Planning Application: Seeking advice on an **OUTLINE** planning application with all matters reserved for 6 No. detached houses with detached garages.

Reference: **WA/26/18/OUT**

Location: **Former Lanes End House, Walberton Lane, Walberton**

Former Lanes End - Six Six bedroom detached Houses with Garages Proposed Layout Scale 1:100 @ A3 (c) PJ Developments LTD 2018		REVISIONS		01
		MM/DD/YY	REMARKS	
	1	--/--/--	...	A
	2	--/--/--	...	
	3	--/--/--	...	
	4	--/--/--	...	
	5	--/--/--	...	
West Walberton Lane Proposal

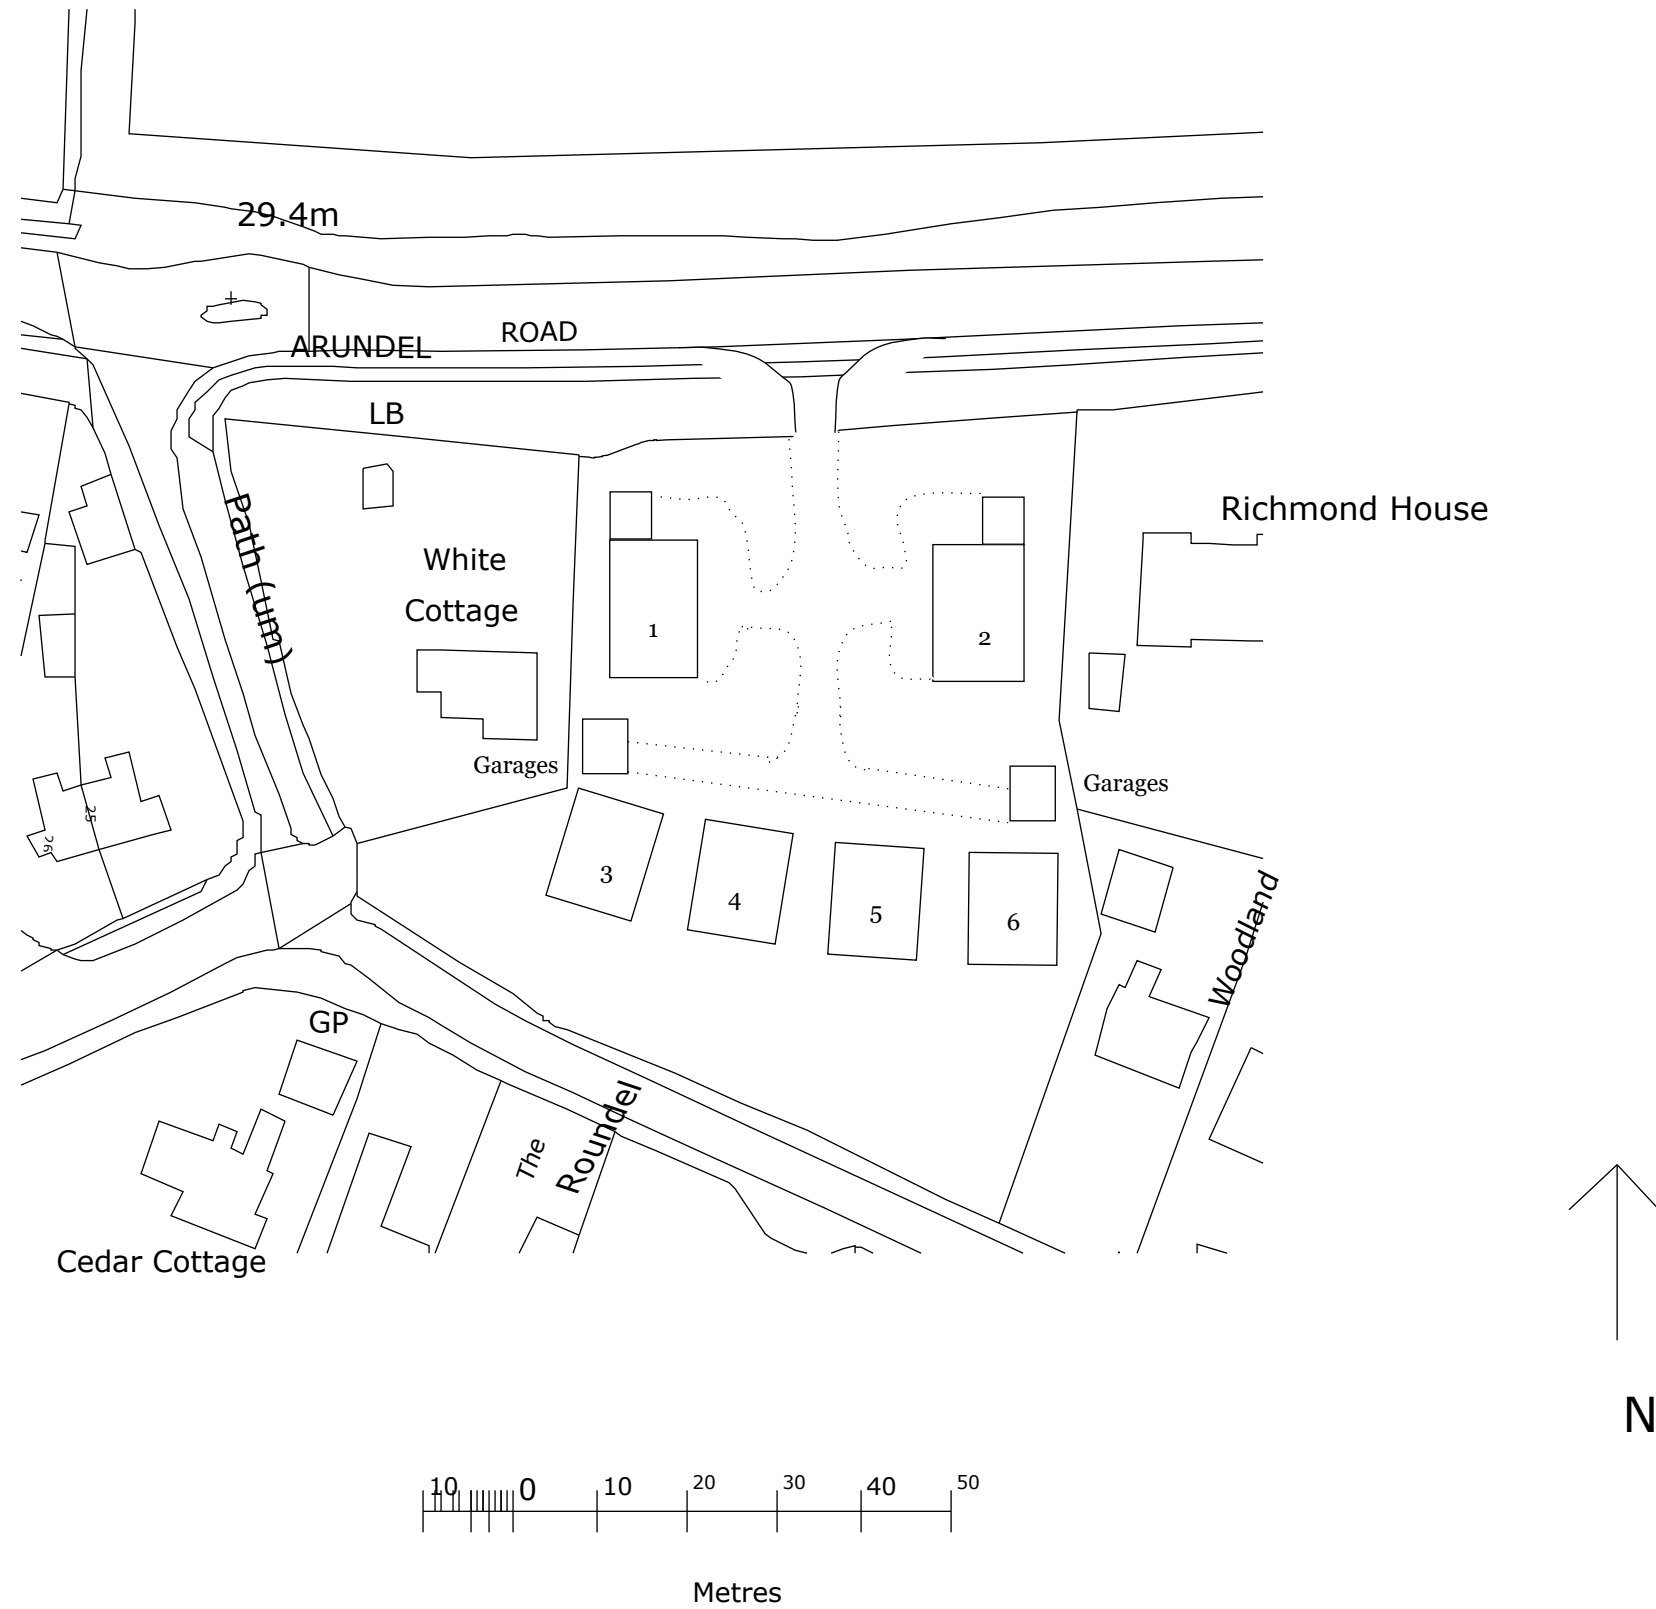
- The applicants have not submitted any supporting arboricultural information.
- I noted on my inspection that there are trees around the periphery of this Plot and also densely wooded gardens on either side of it which would be impacted by these proposals compromising their Root Protection Areas and contrary to the recommendations of BS5837: 2012.

- No supporting arboricultural information has been submitted with this application despite the fact that there are clearly trees both on and off this site which require consideration and full respect in terms of BS5837 recommendations.

- The applicants will need to supply an **Arboricultural Impact Assessment & Tree Constraints Plan** before I can assess the impact that the proposals might have on the existing tree stock.
- I therefore register an **OBJECTION** on the grounds that no supporting arboricultural information has been submitted with this application.
